Date: 14-Oct-2025
Our Ref: 2025/92187

**Application for Approval of Details Reserved by Condition
Town and Country Planning Act 1990
Planning (Listed Buildings and Conservation Areas) Act 1990**

Frankie And Bennys, Centre 27 Business Park, Bankwood Way, Birstall, Batley, WF17 9TB

Application Number: 2025/92187

DRAWING NUMBER
16209-2003

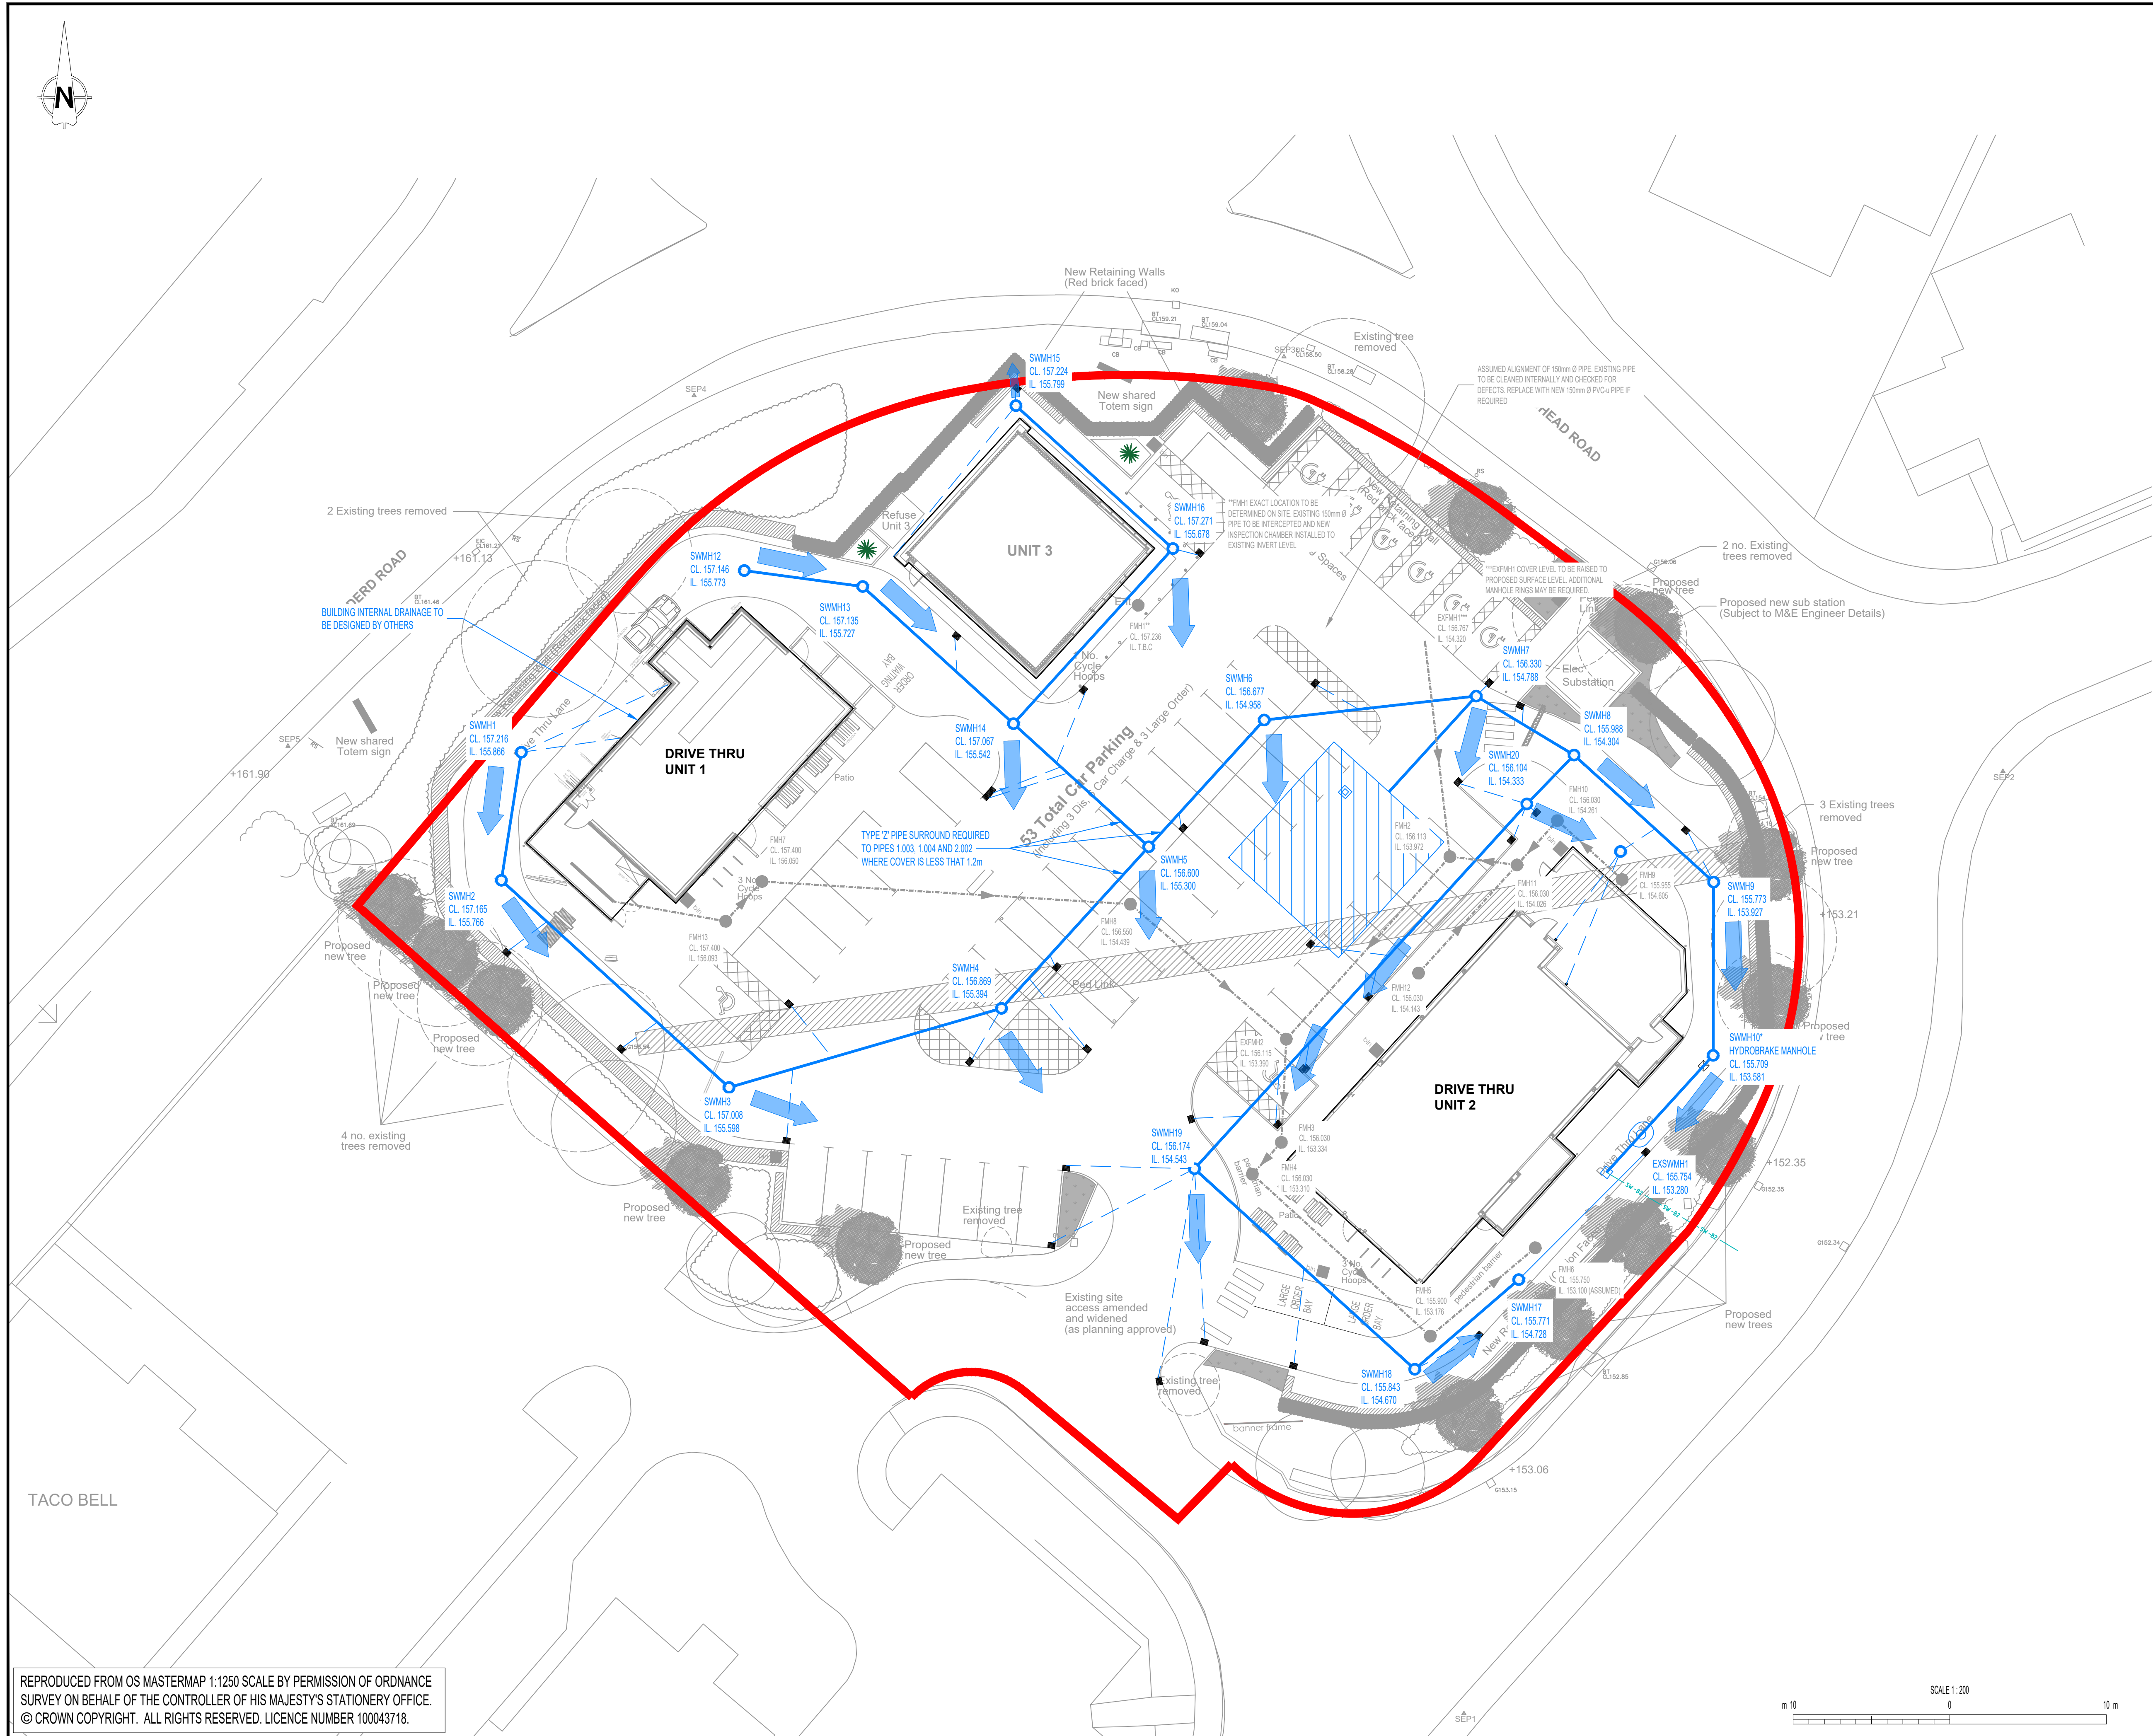
The above information has been reviewed by the LLFA. The submitted flood exceedance routing drawing is accepted by the LLFA; for this condition to be discharged, no part of the development shall be brought into use (dwellings shall not be occupied) until the works comprising the approved scheme have been completed, and the approved scheme shall be retained thereafter.
